March 22, 2019

**SUBJECT: Settlers Ranch Filing No. 2C  
Response to County Review Comments  
SF-18-18**

PCD File No. SF-18-018

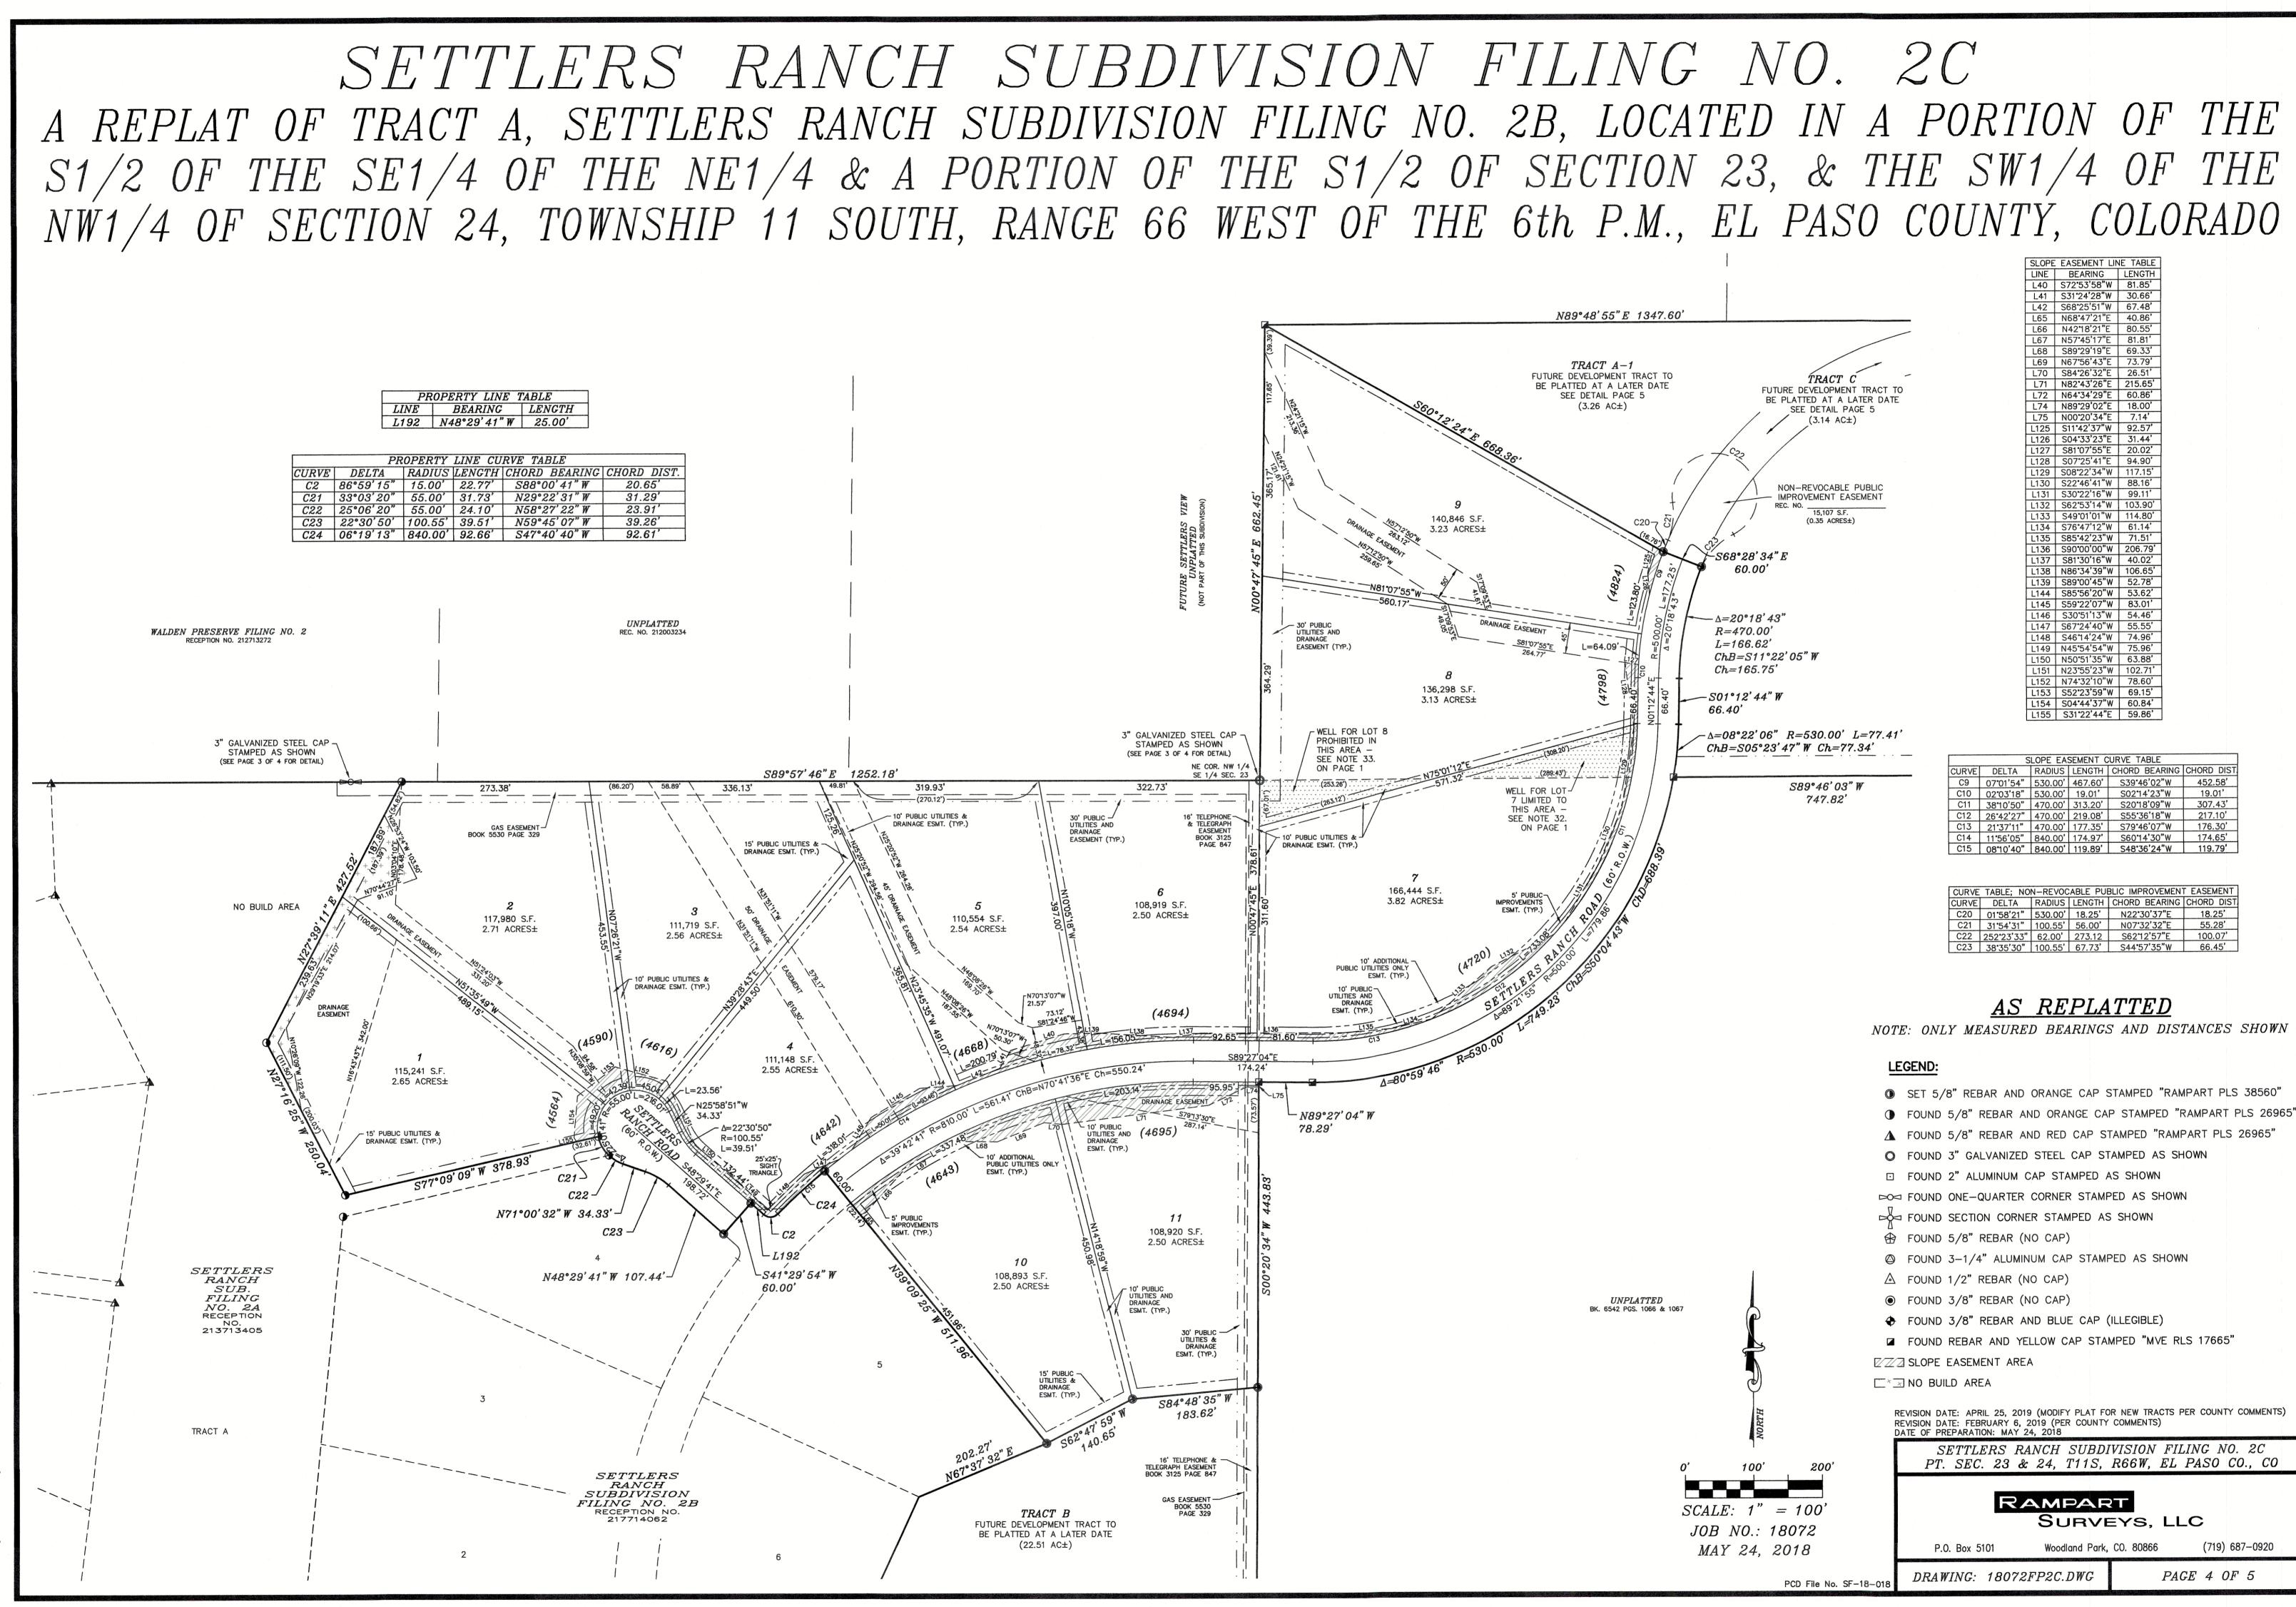
MVEA acknowledges the easements shown in the plat of ten (10) foot side, fifteen (15) rear and twenty (20) foot front lot line utility easement along with a thirty (30) foot exterior easement on plat. MVEA request utility easements be included with the Public Improvement Easements along the front lot and tract line to aid in the design and the platting of existing MVEA facilities with easement on the plat. If open space, drainage and landscape tracts are designed in this filing MVEA requests these areas be listed to include utilities. Additional easements may be required once a review of civil drawings with grading and erosion plan is provided to MVEA in order to serve this subdivision. **(Utility easements are included with the Public Improvement Easements as stated in easement note - overlaps 5' public improvements easement for a total of 20 feet)**
